PLANNING AMENDMENT

H14/0099/00

Description: Erection of B1 (Light)
Industrial units - Plots 9 -
13

Amendment: Revised layout plan showing revised plot numbers
(9-13) to (6-10)

Drawing SHEP-003

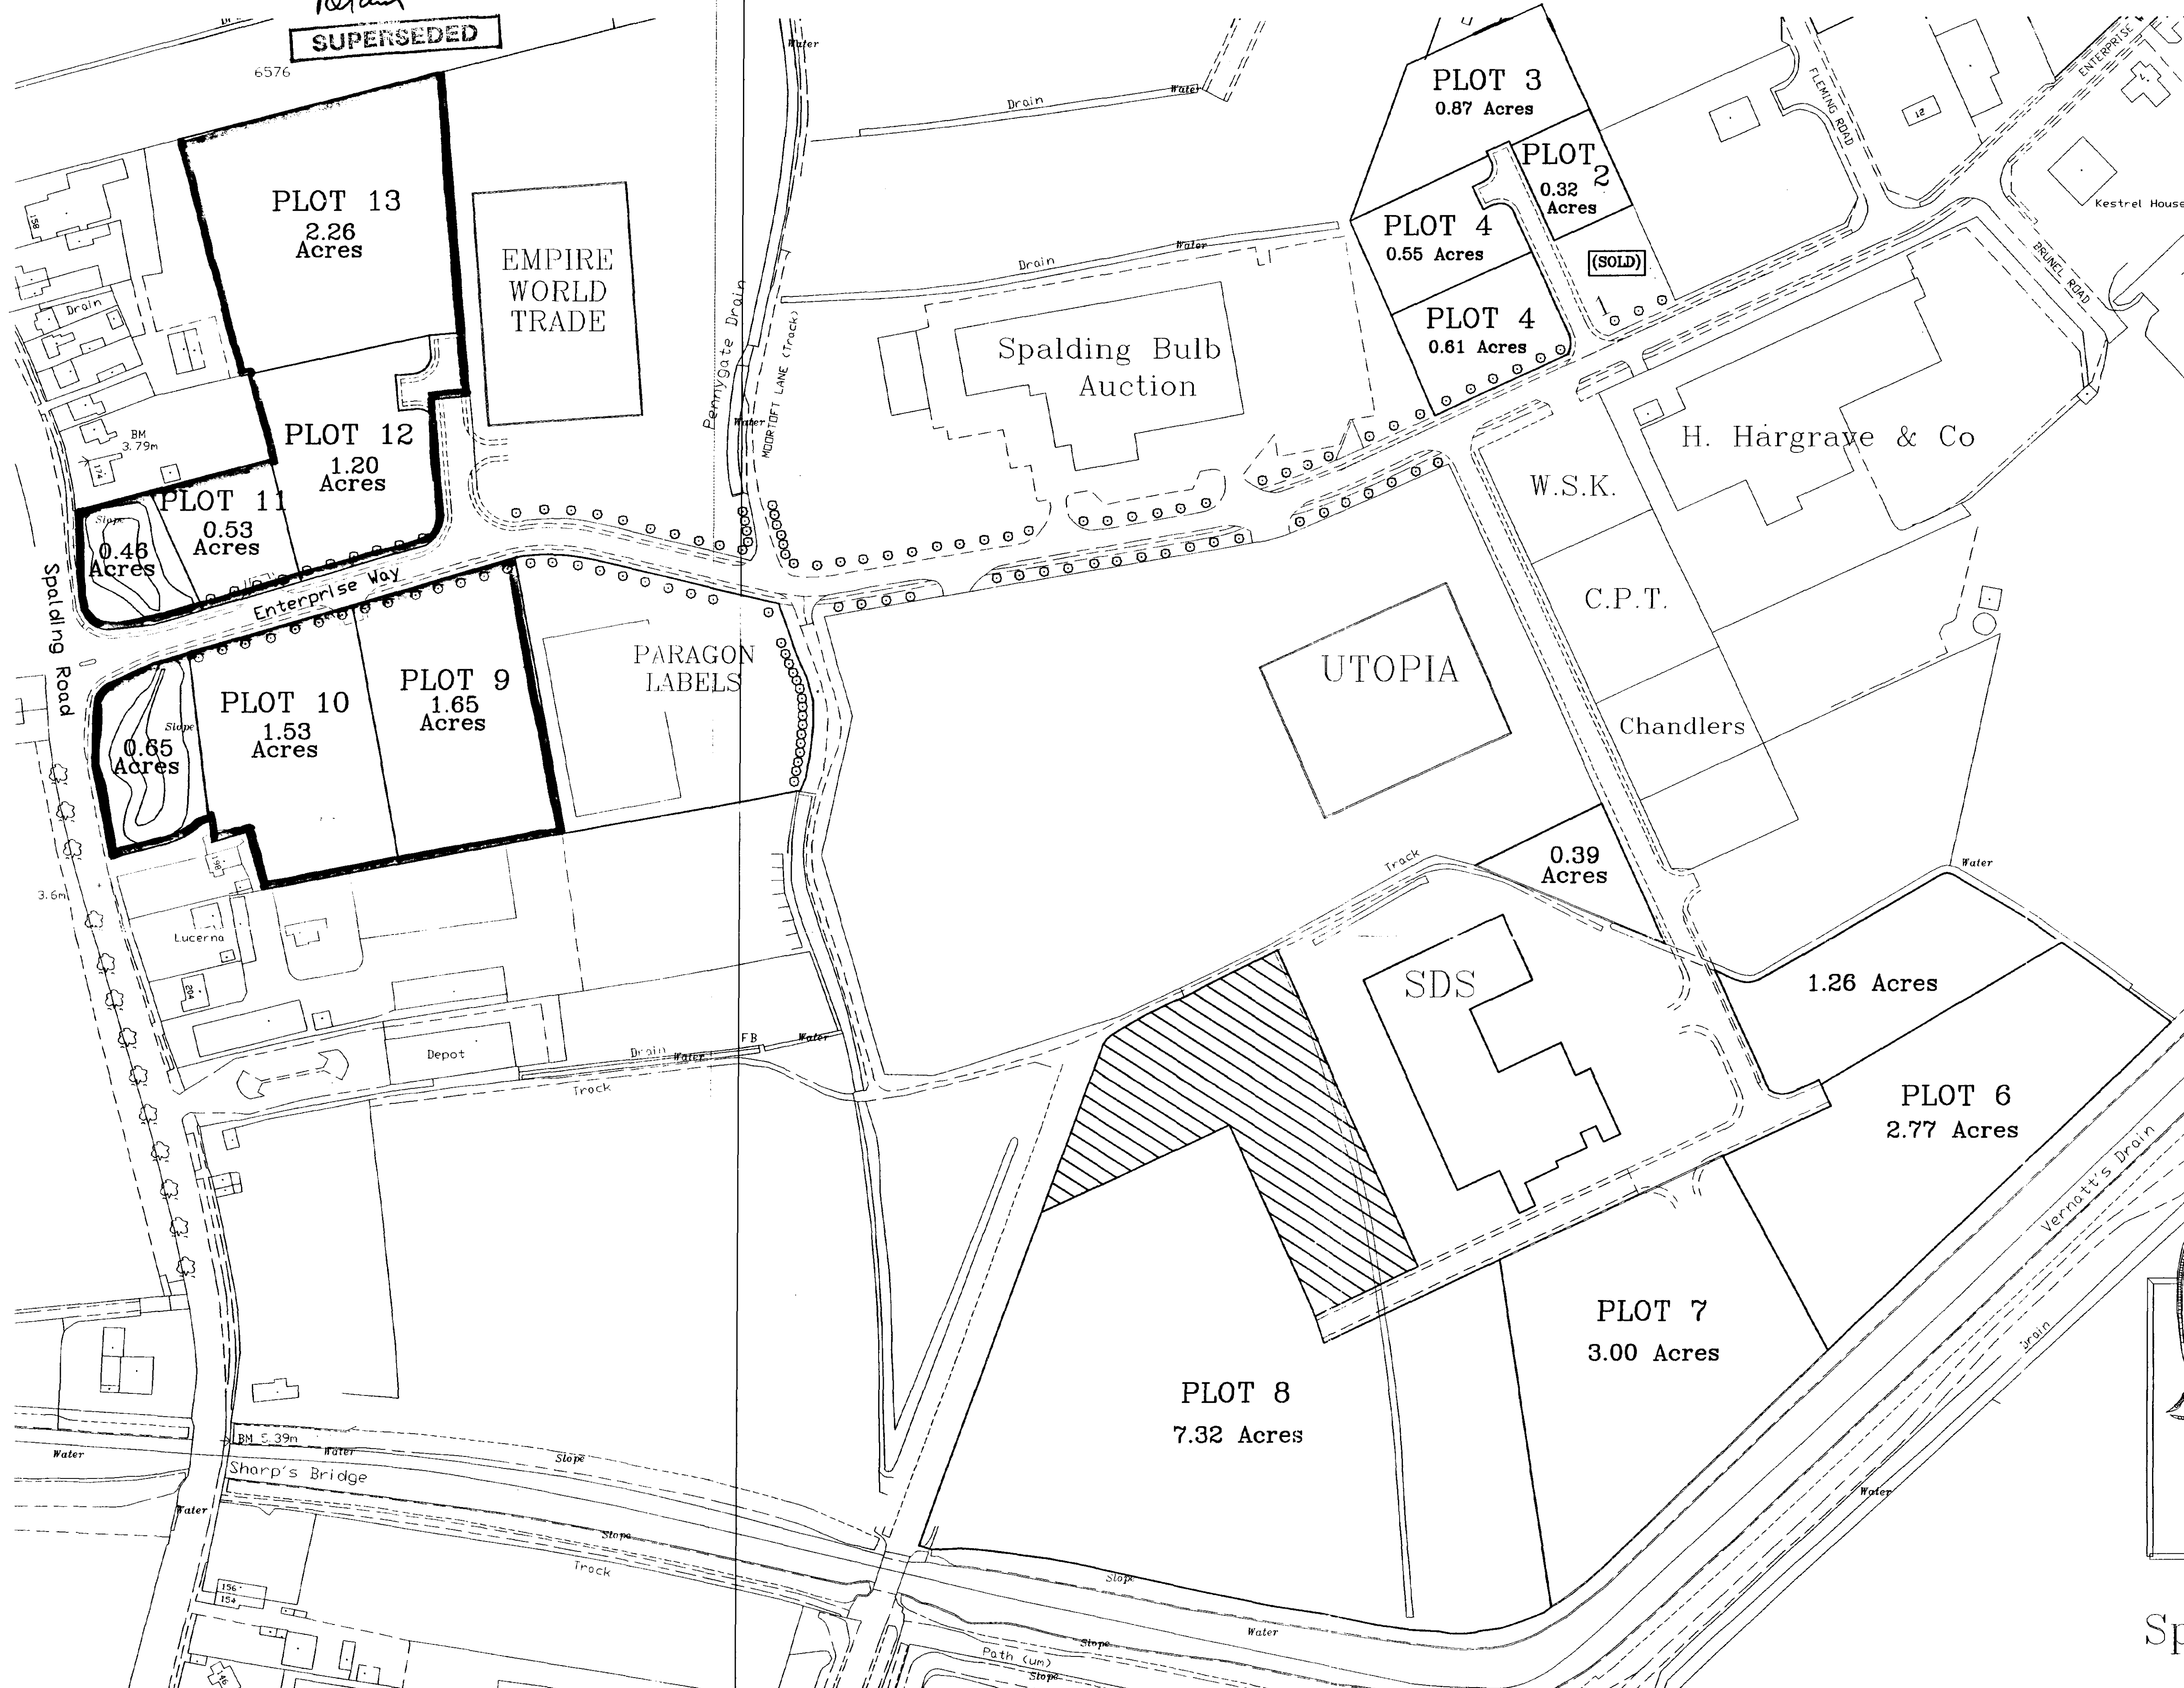
Reason: Plans show different site area.
